CITY OF ALBUQUERQUE

June 3, 2013

Re: Dolores Gonzalez Elementary School, 900 Atlantic Ave. SW
Grading and Drainage Plan
Engineer's Stamp Date 05-01-2013 (K-13/D031)

C-101

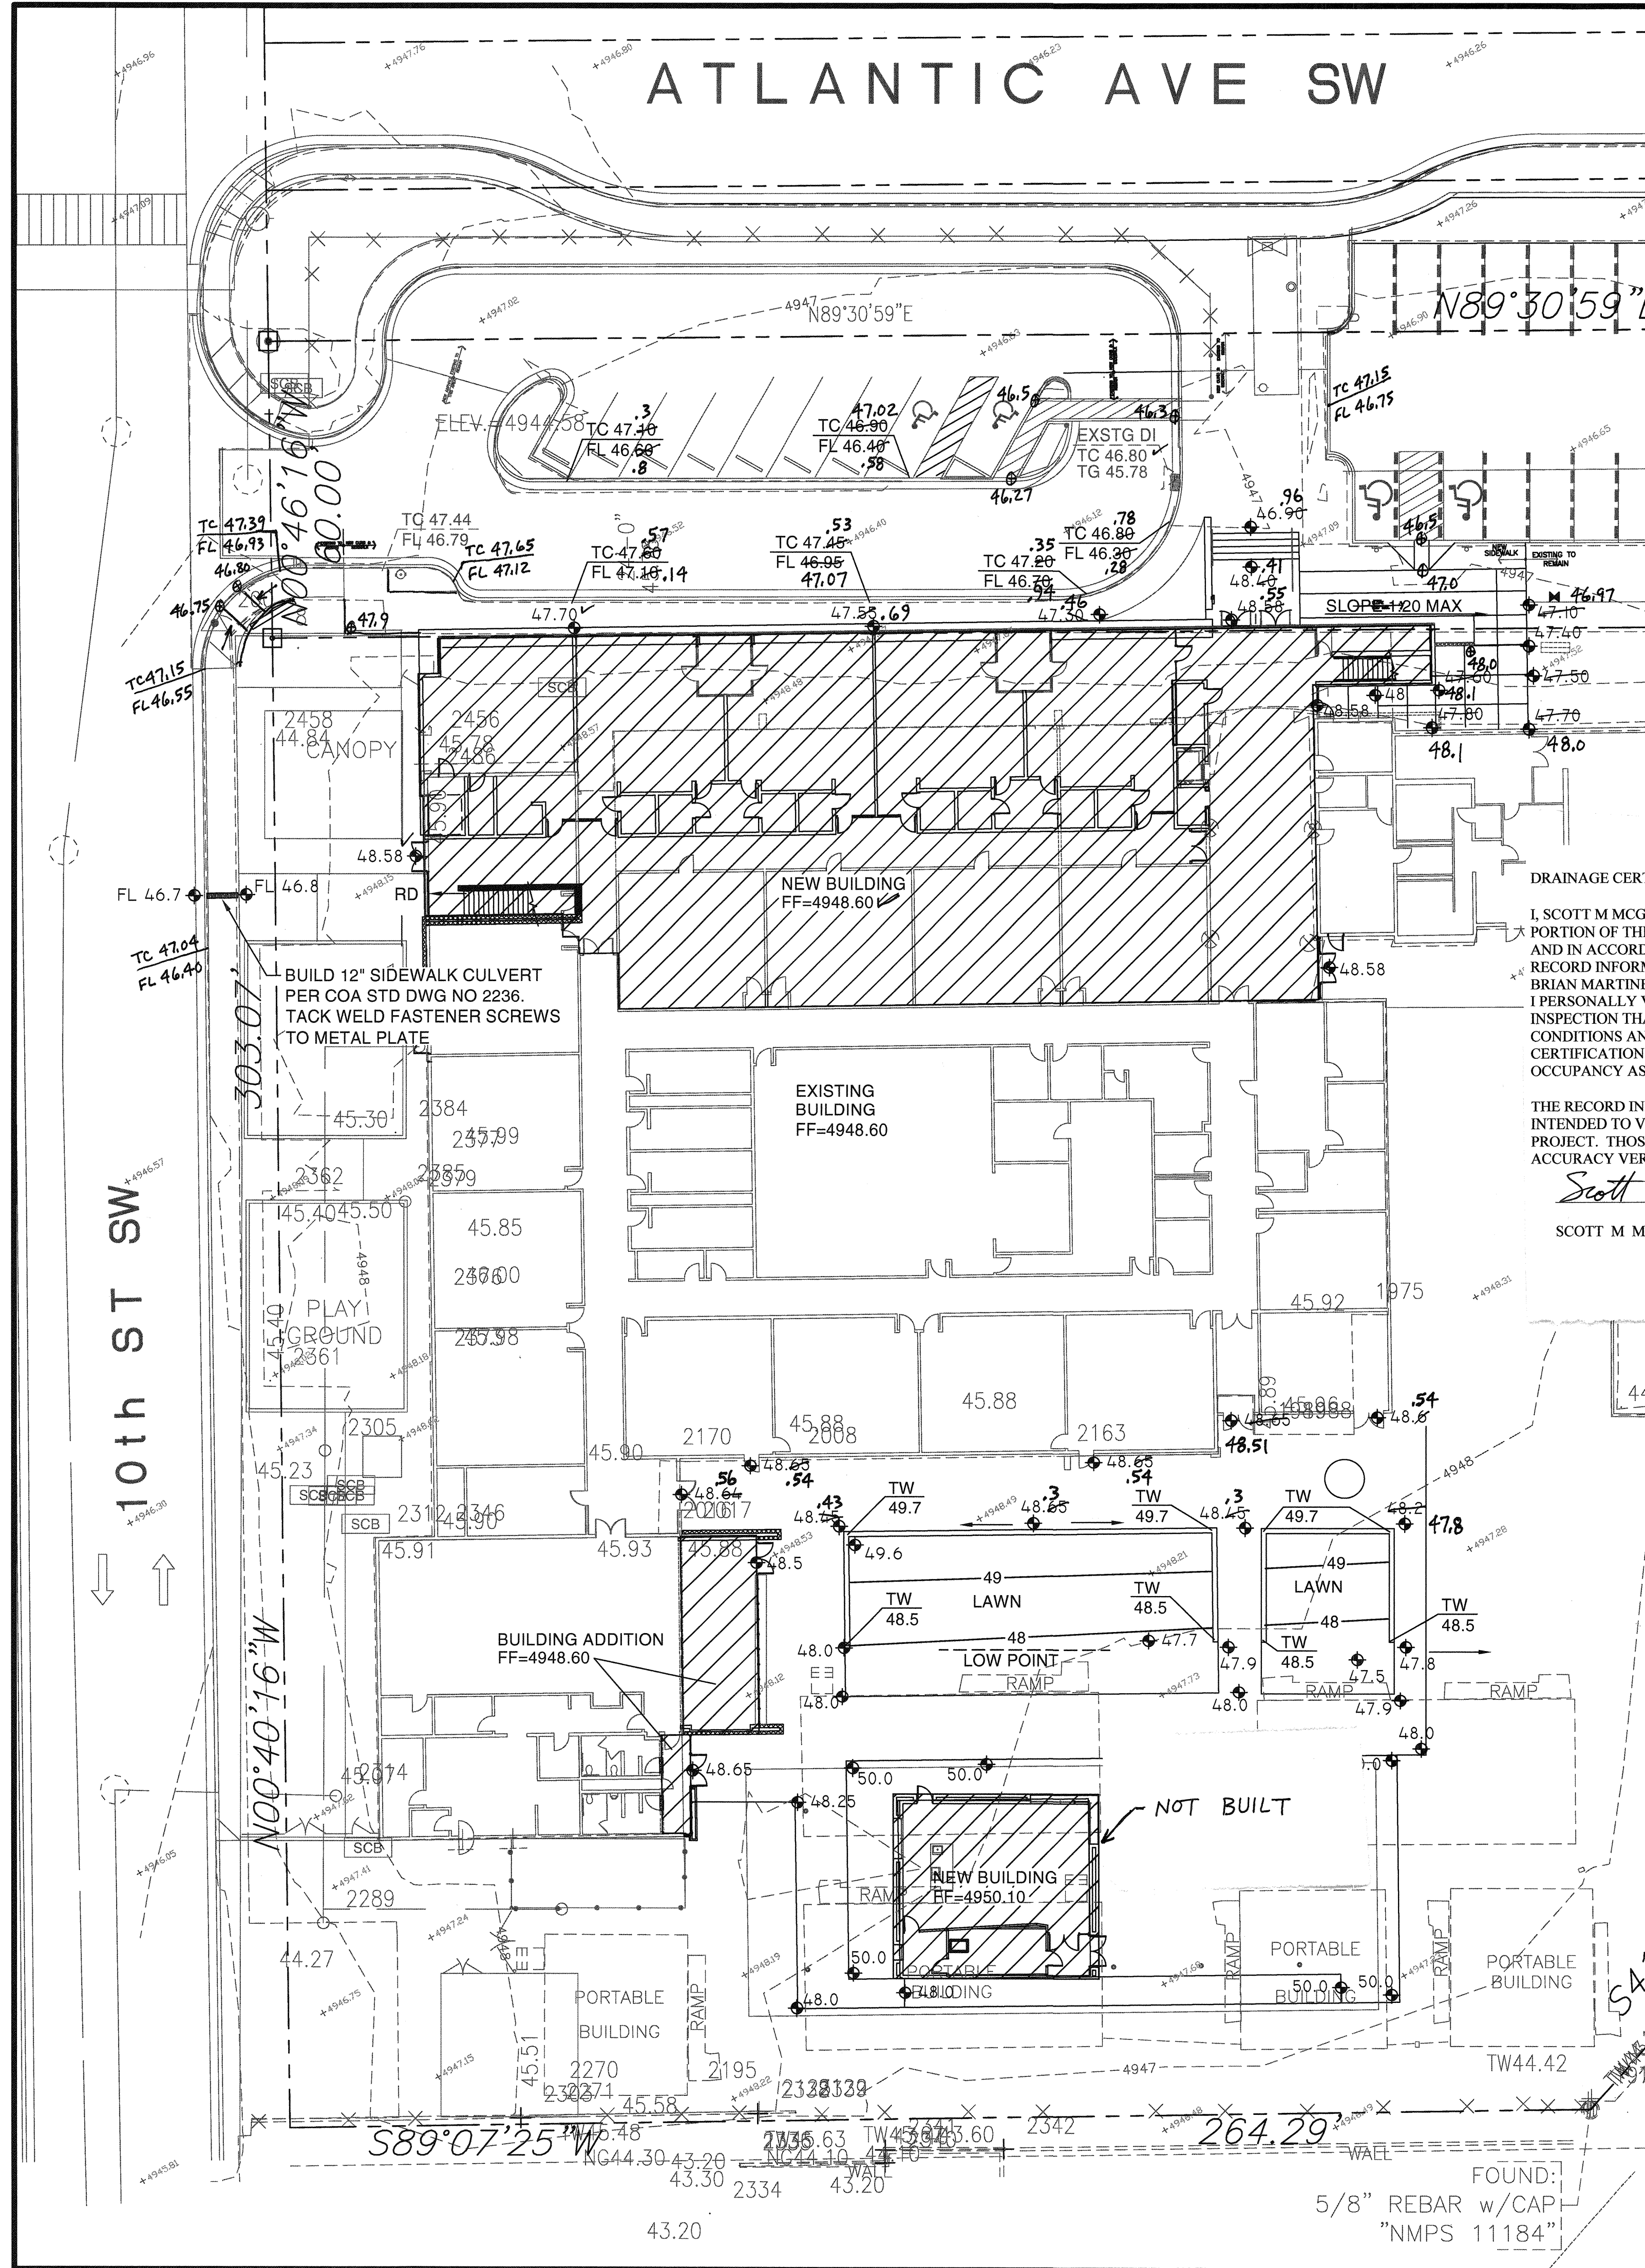
- 1) Provide a copy of the approved encroachment agreement.
- 2) The sidewalk culvert in the City ROW must be inspected and accepted. Please contact Jason Rodriguez, 235-8016, to schedule an inspection.
- 3) Provide an Engineer Certification for our files as well as an as-built PDF for our electronic records.
